From: Richard Cutler [REDACTED]
Sent: 10 November 2020 11:50
To: Bernadette Owens <Bernadette.Owens@Cherwell-DC.gov.uk>
Cc: Bruce Usher [REDACTED]
Subject: Re: 20/02779/REM - Land adj Promised Land Farm

As you know, we feel Phase 2 has been a lost opportunity in place-making, but planning permission was issued over the summer and there comes a point where objections need to cease. So we will not be objecting to this reserved matters application and we will leave you to process this submission in line with the expectations set by the outline. In this regard, I would be grateful if you could consider the following points:

18022 - TP - 103

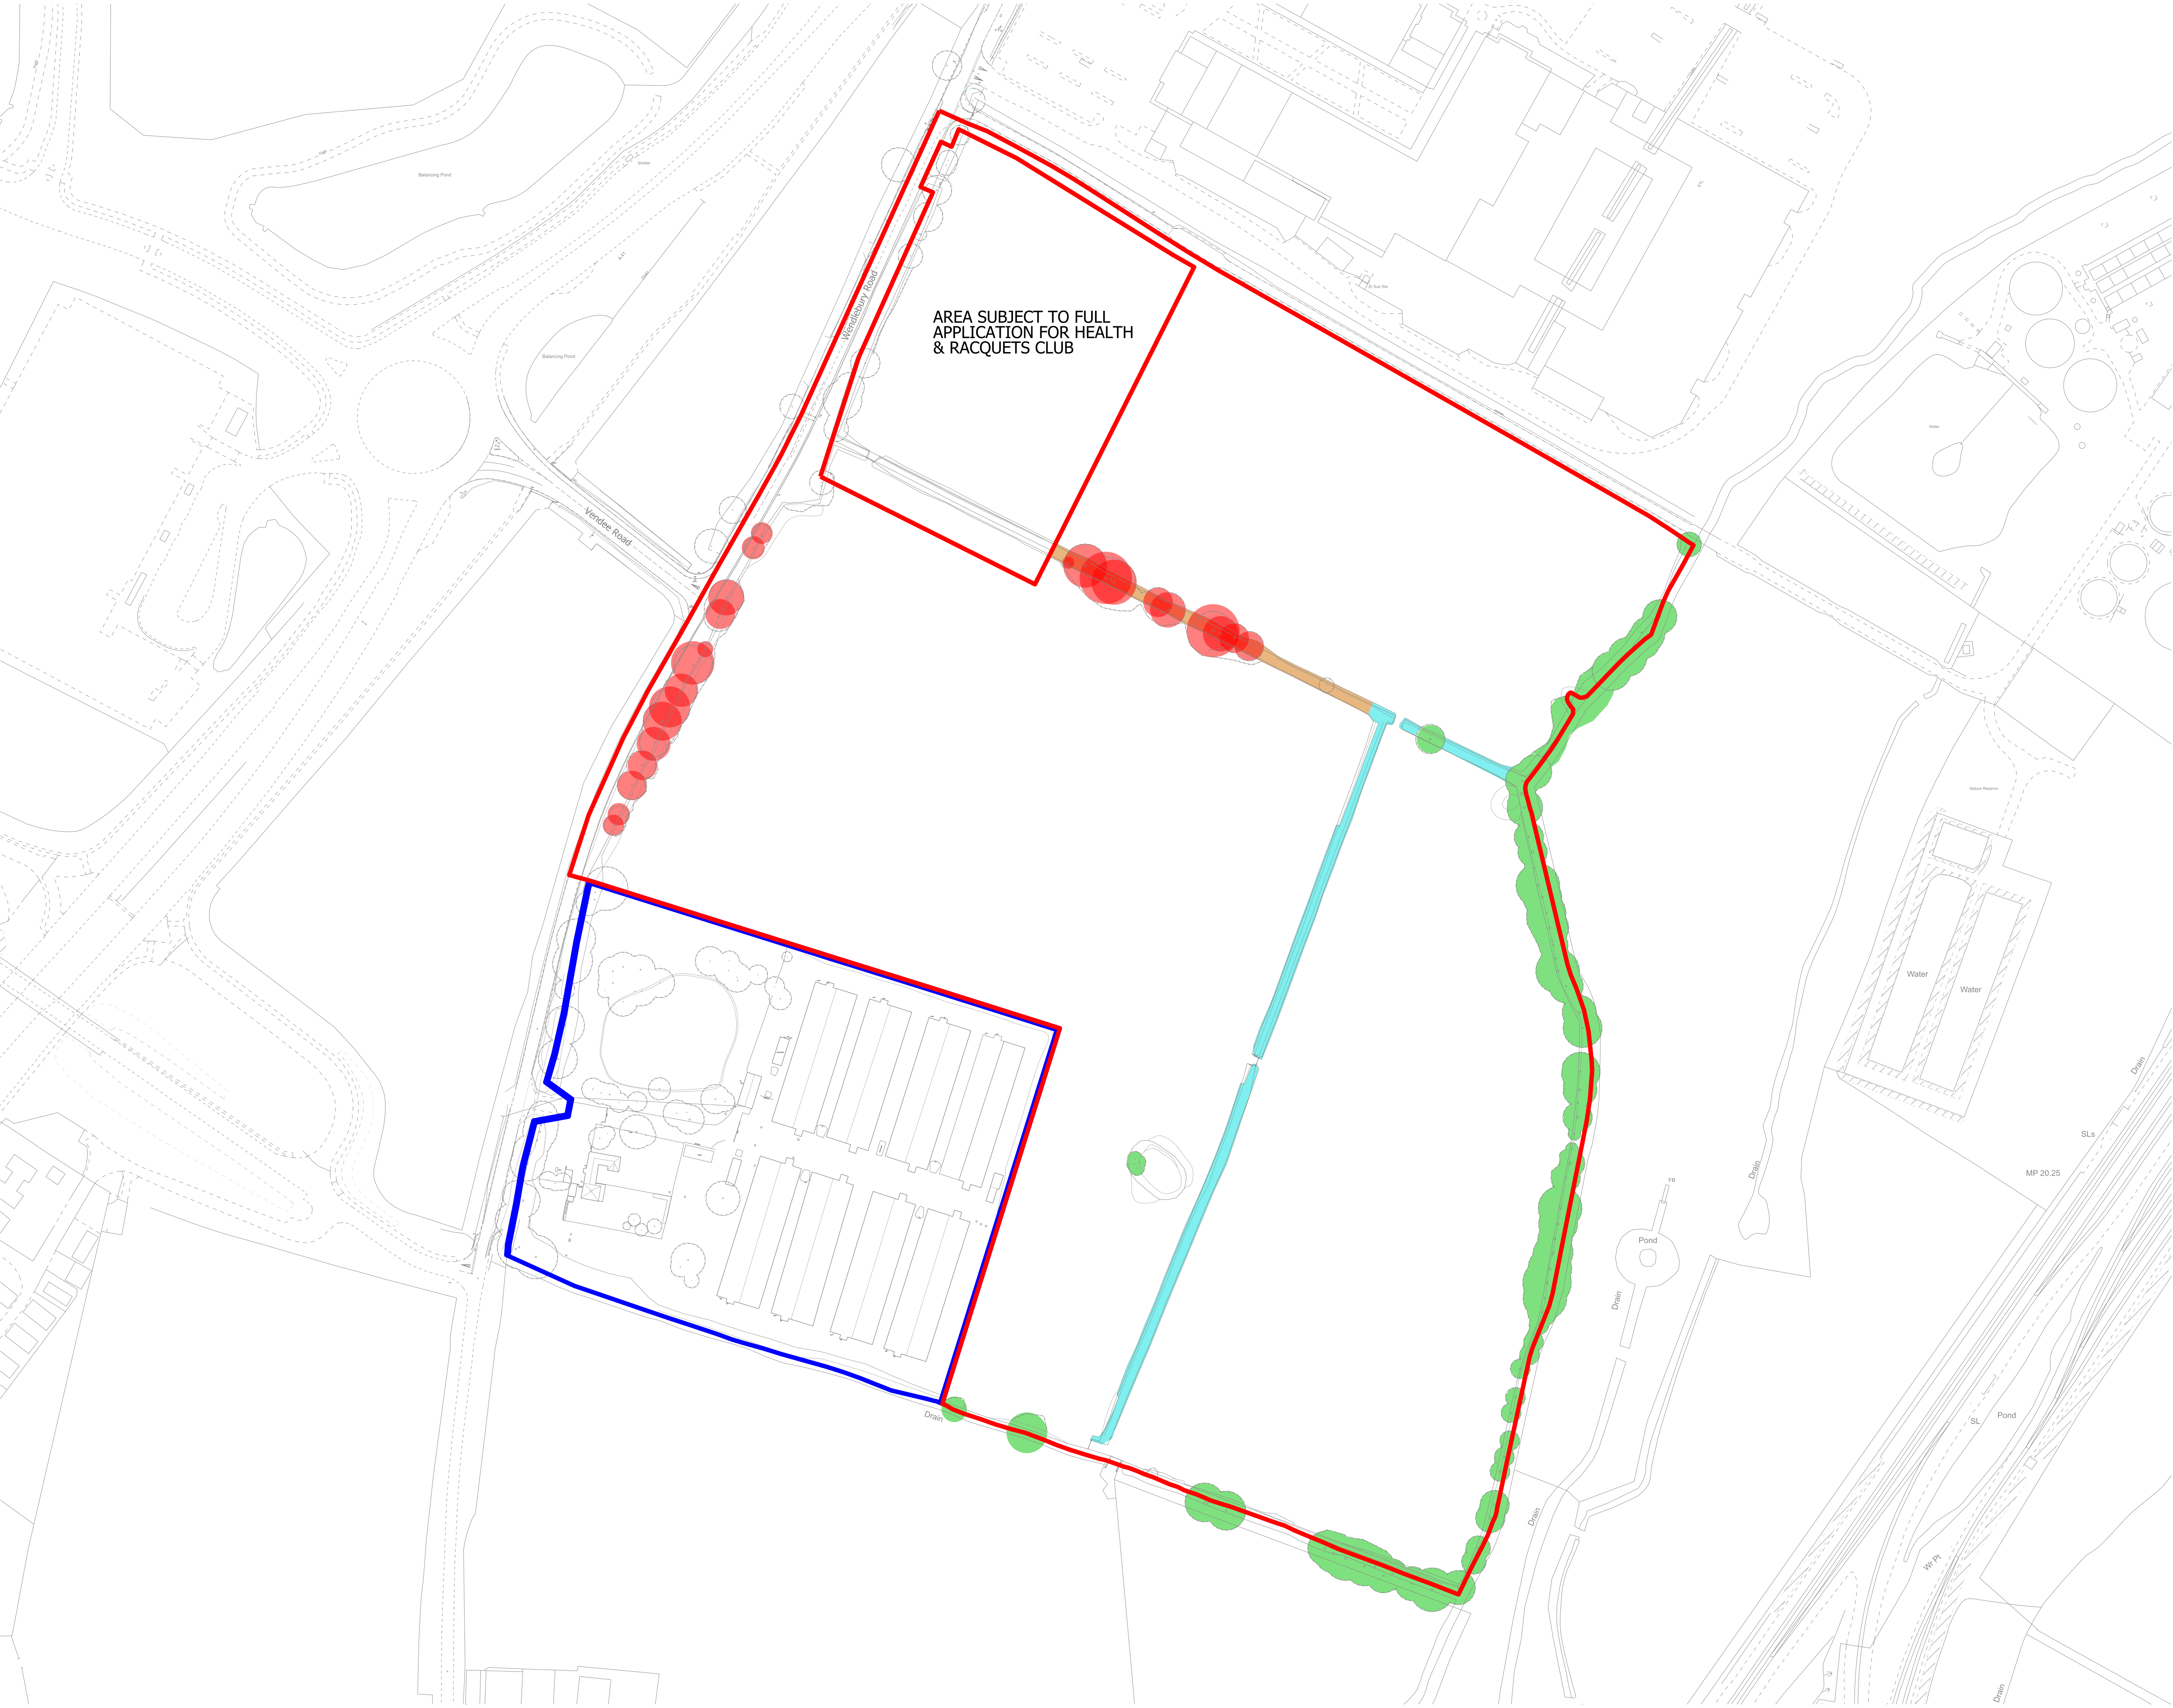
4. This reserved matters application does not provide a case for removing so many trees along Wendlebury Road (Parameters Plan 3).
5. Paragraph 1.3 of the parking note refers to 25% offices (on the first floor) and this same document also refers to B2. This is consistent with the industrial nature of the master plan and a lower employment yield.

Drawing No. 18022 - TP - 121 Rev. D

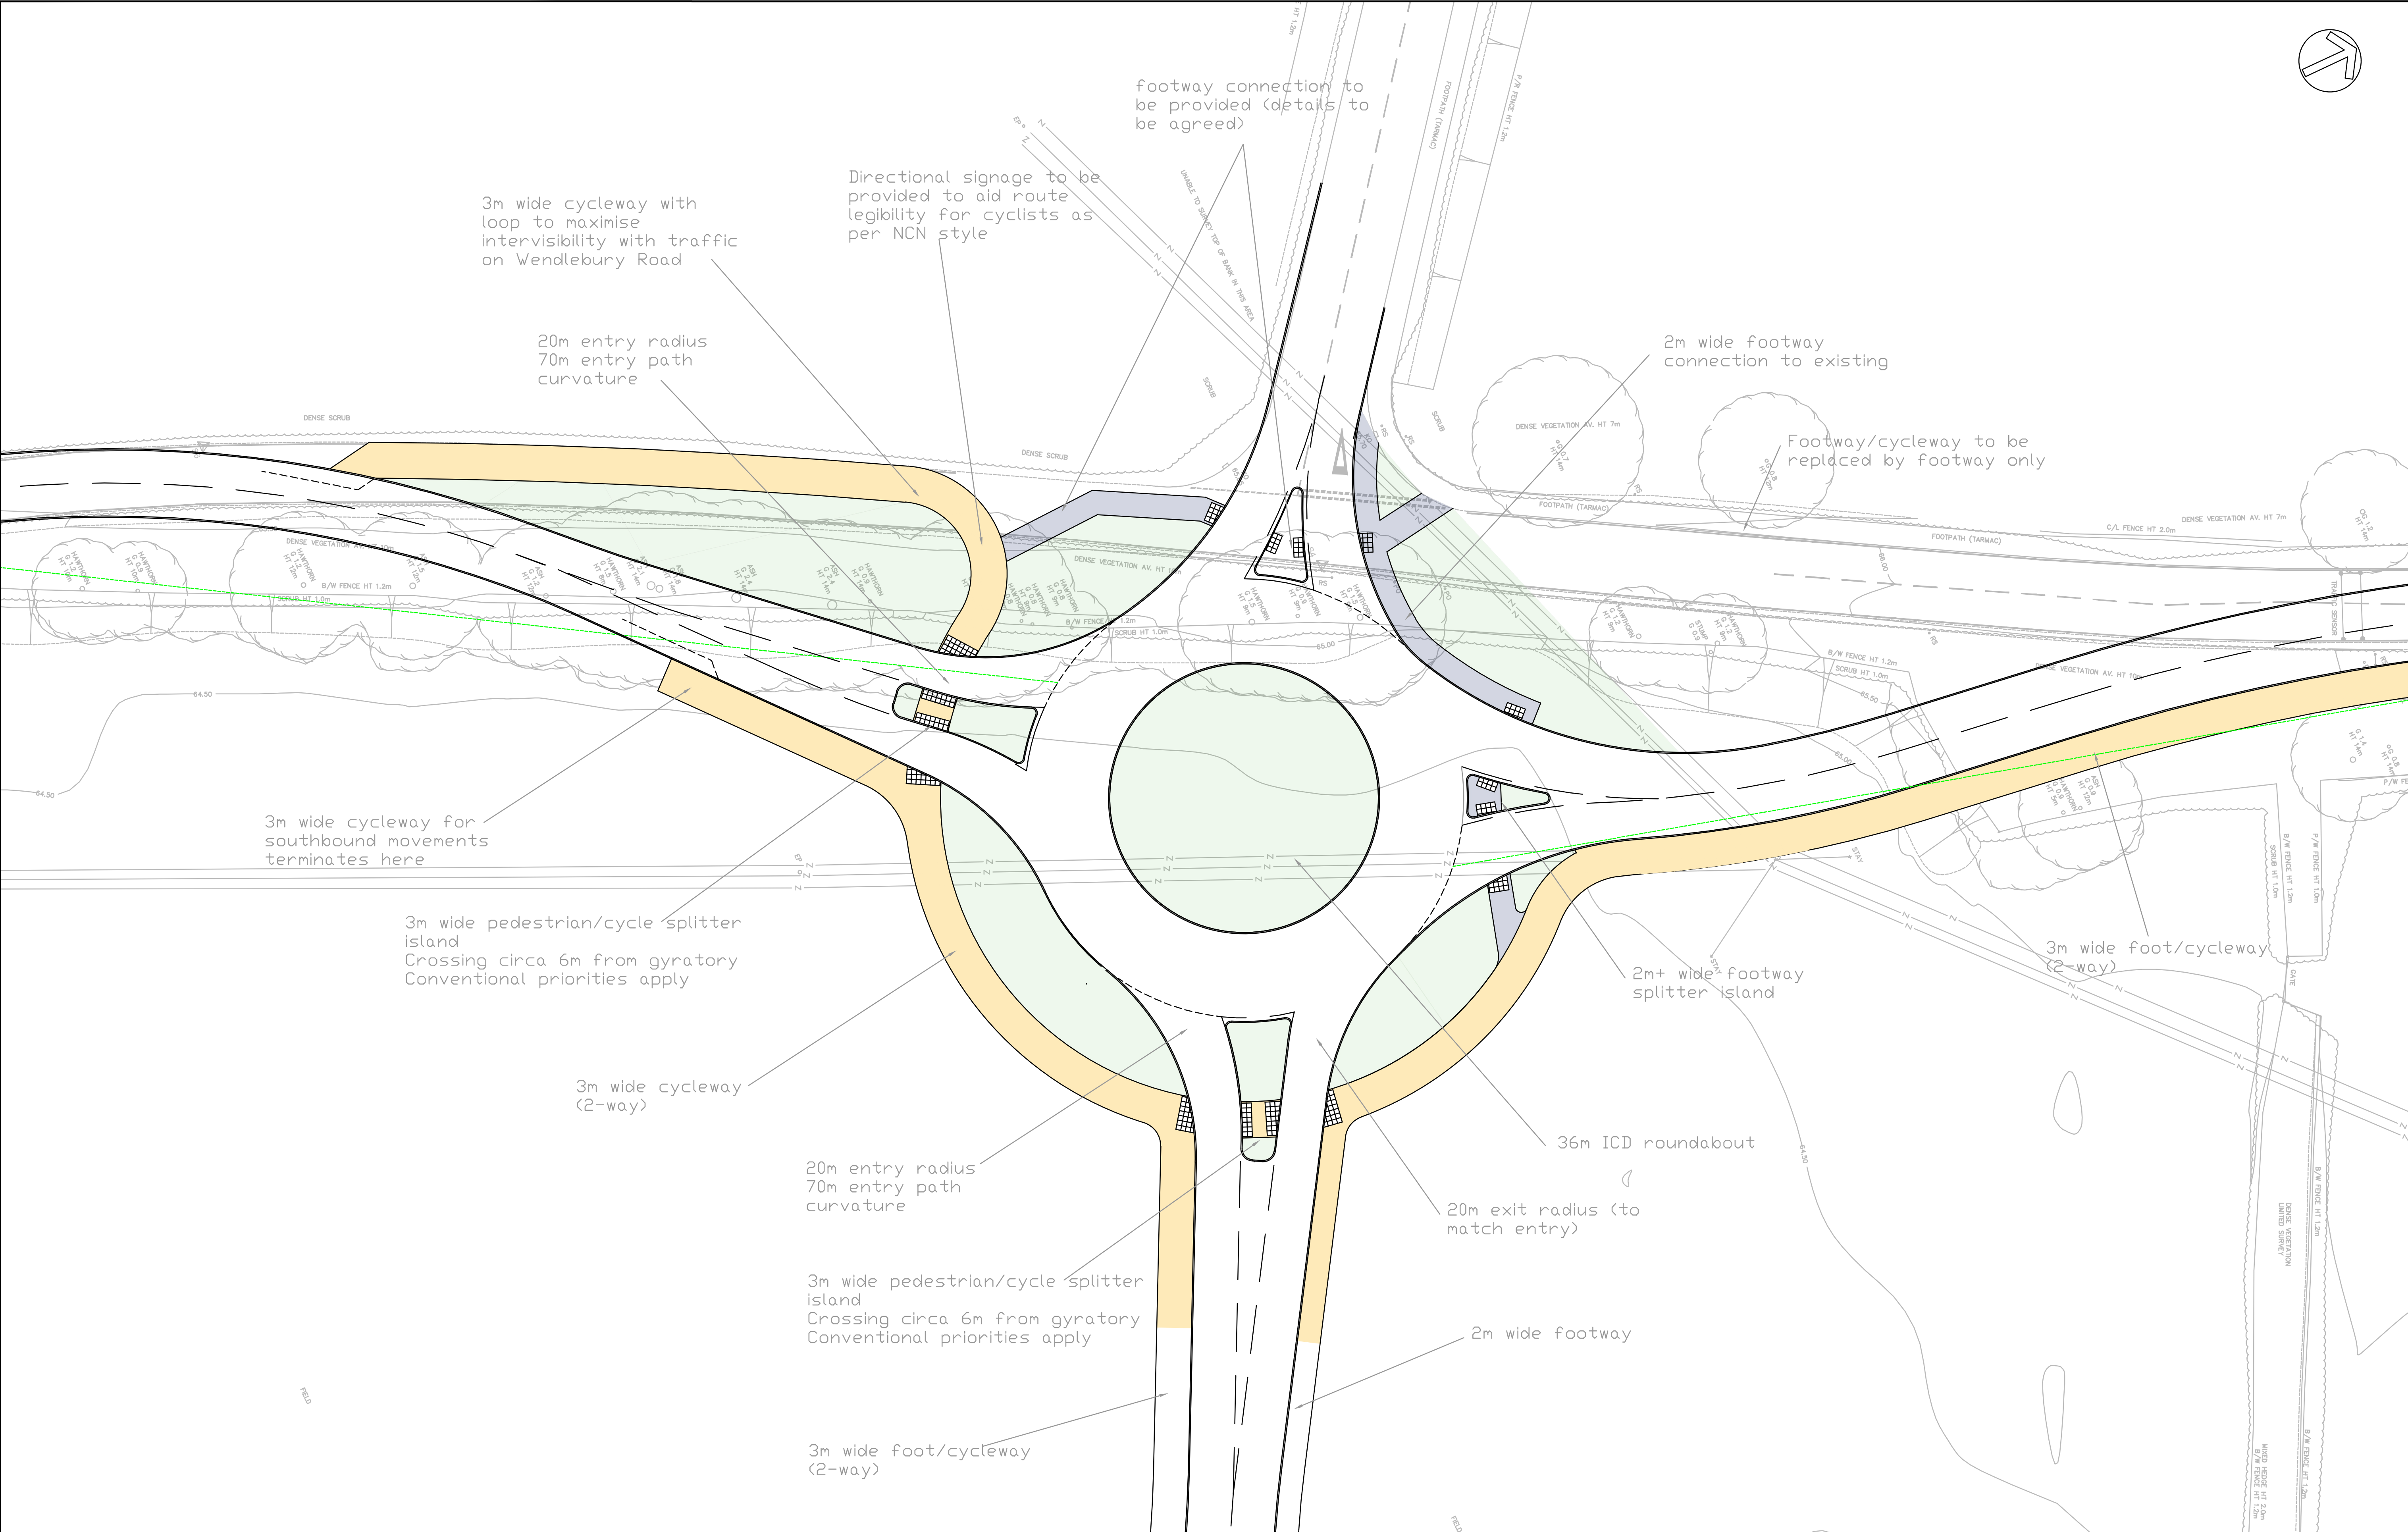
- c. It would be good to see clearly how Phase 2 provides for pedestrian access to the hotel on Phase 1A. Accessibility to the DLL is also unclear, including from Phase 2 (eg for lunchtime exercise), where it seems that the only access is from Wendlebury Road. See the Development Framework Plan and External Works Layout. In short, the plans cannot be described as permeable.
